Report of the Head of Development Management and Building Control Committee Report

35220/APP/2024/3046

Applicant: **Mr M Madhang**
Site Address: **44 Frays Avenue, West Drayton, UB7 7AG**
Proposal: **Demolition and reconstruction of new build family home.**
Summary of Recommendation: **GRANT planning permission subject to legal agreement and conditions**
Reason Reported to Committee: **Required under Part 3 of the Planning Scheme of Delegation (Petition received)**

1 Ground Floor
1 : 100

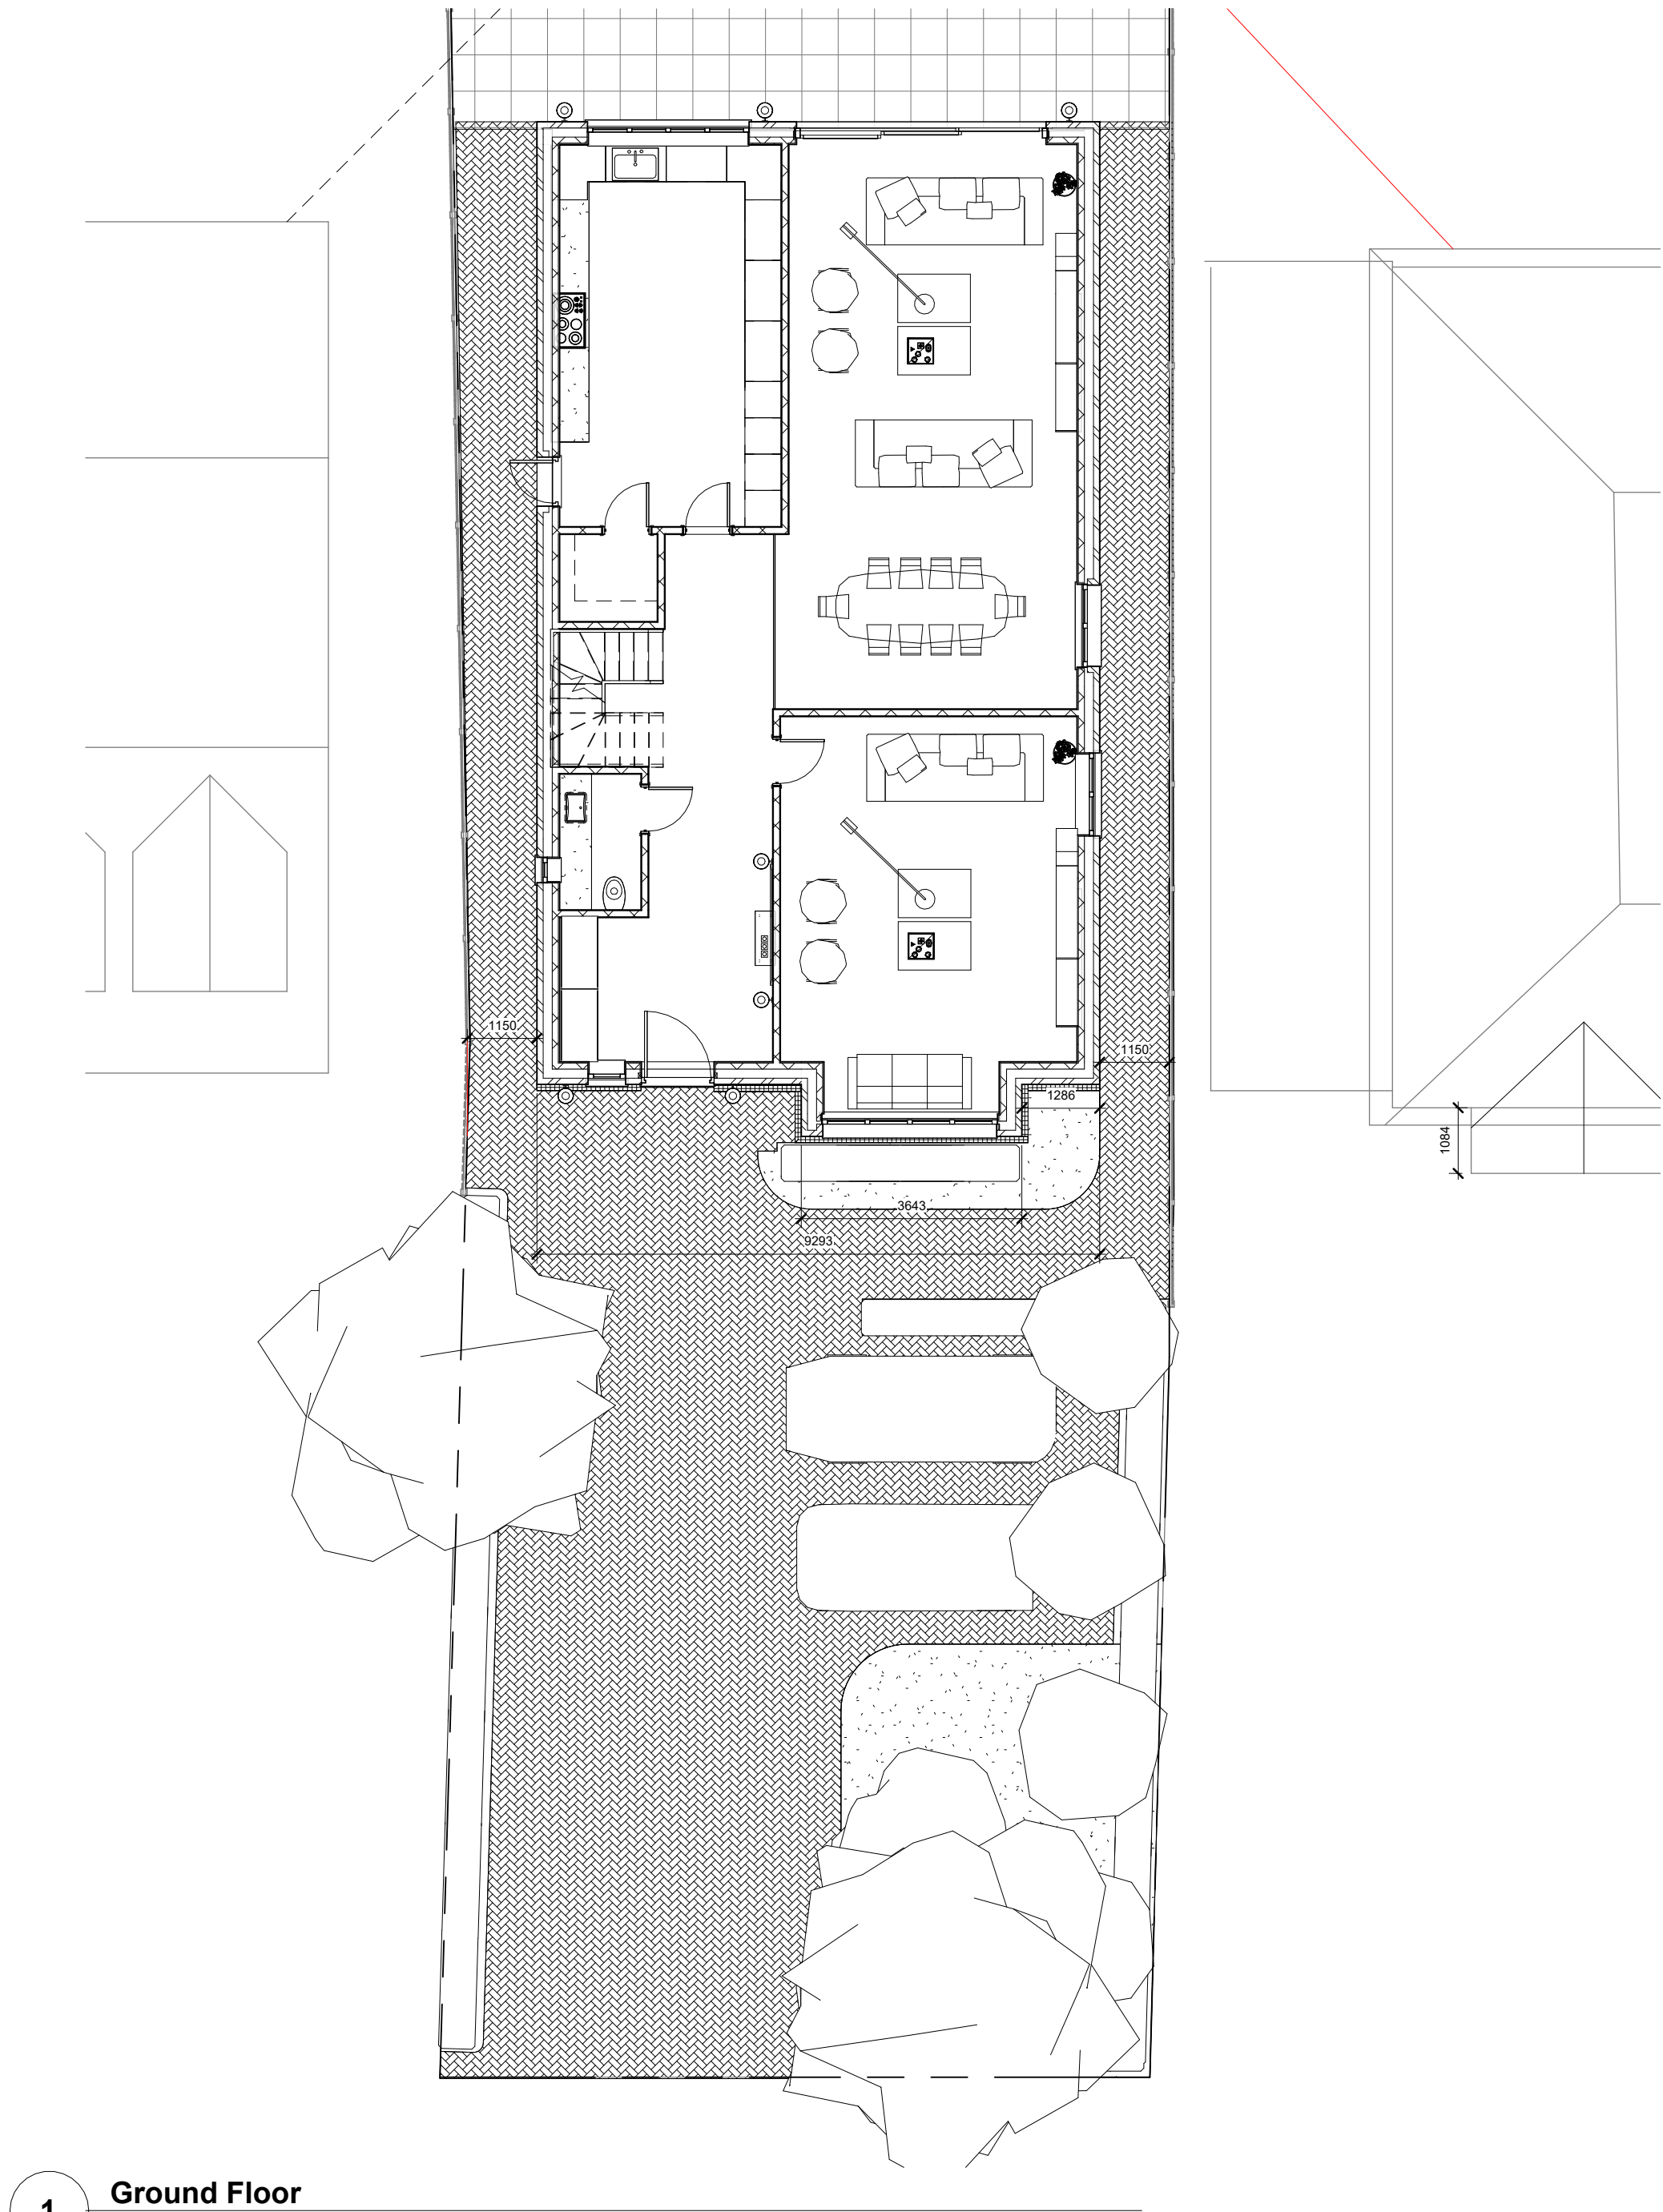
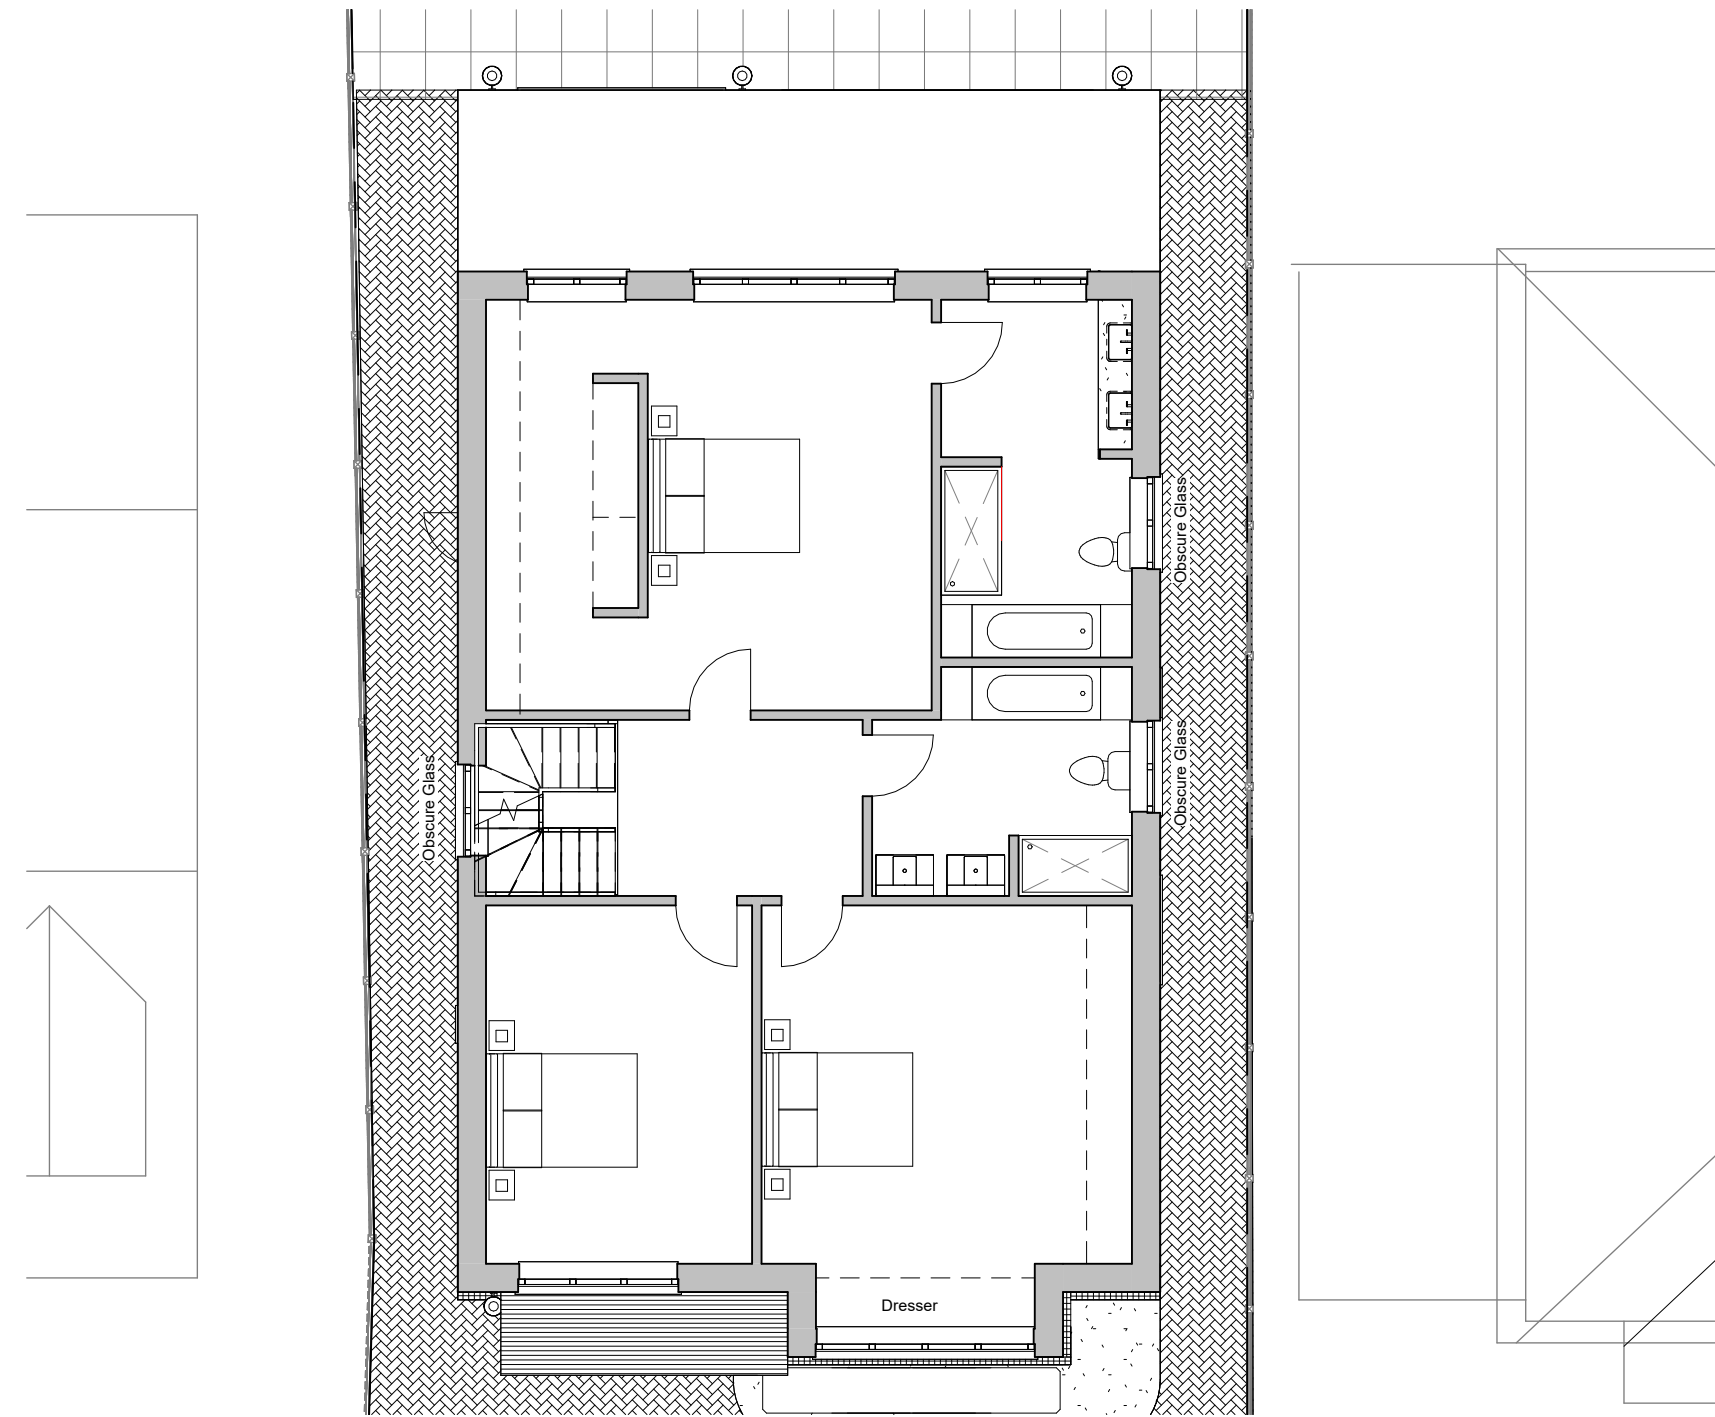
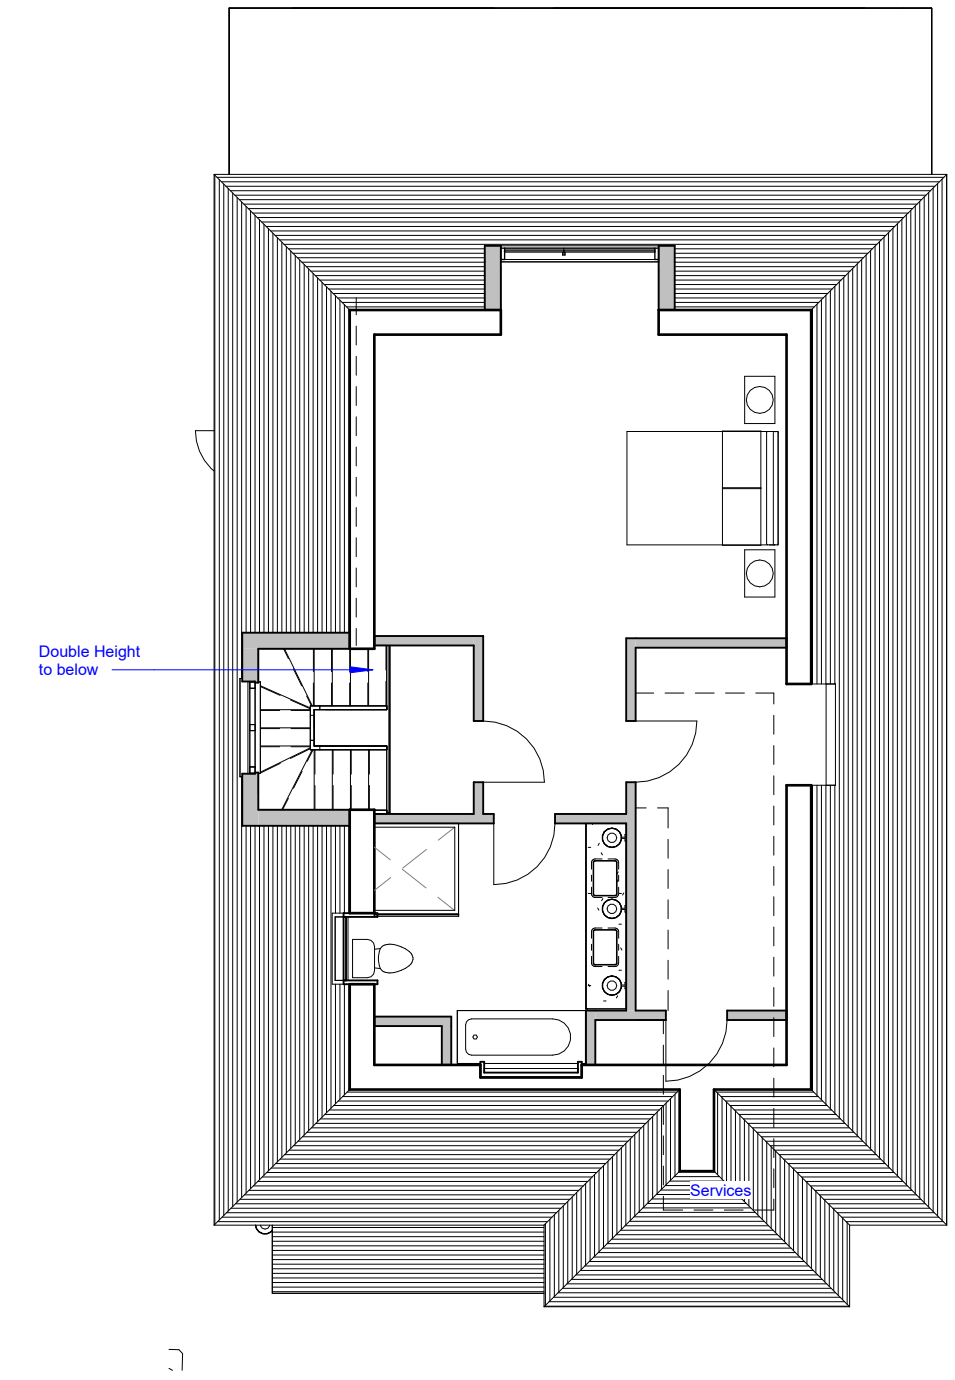
- 7.10 The rear dormer would occupy less than one third the width of the rear roof slope. It would be set down 0.4 metres from the ridge and in a central location with satisfactory set-ins from the side elevations. Whilst the window serving the rear dormer is quite large, the proportions of the rear dormer are considered to be acceptable. It would also not be overly visible from the street scene and as such, no material harm is identified.

- 7.11 The side dormer is 2.5metres wide and would be set down 0.40 metres below the main ridge. It would be set back 5.3 metres from the front elevation. The side dormer is relatively narrow and set back from the street scene and when viewed against the side roof slope which measures 13.8 metres, it would not be unduly prominent. It is noted that there are other examples of side dormers on the neighbouring properties at Nos.41, 47 and 54. As such the side dormer would not introduce an alien feature to the street scene.

- 7.12 The resubmission scheme has replaced the previously proposed forward gable projection on the proposed replacement dwelling with a hipped roof. A further revision was received to reduce the forward projection further and is now comparable to those found on properties in the street scene. The revised forward bay projection reads as a subordinate feature and appears acceptable within the wider street scene.

- 7.20 The first-floor side windows serve the stairs/landing and a two bathrooms. All three first floor side windows are annotated to be obscure glazed. A condition would be attached in the event of an approval to secure the obscuring of these windows to preserve neighbouring amenity.

- 7.21 The side dormer would serve the stairs and is recommended to be obscure glazed to prevent overlooking towards No.46. The side rooflight serves a store. In the event of the application being determined for approval, a condition is recommended to be attached to obscure glaze these to preserve neighbour privacy.

The windows at first floor and roof level in the side elevations facing Nos. 42 and 46 Frays Avenue shall be glazed with permanently obscured glass to at least scale 4 on the Pilkington scale and be non-opening below a height of 1.8 metres taken from internal finished floor level for so long as the development remains in existence.
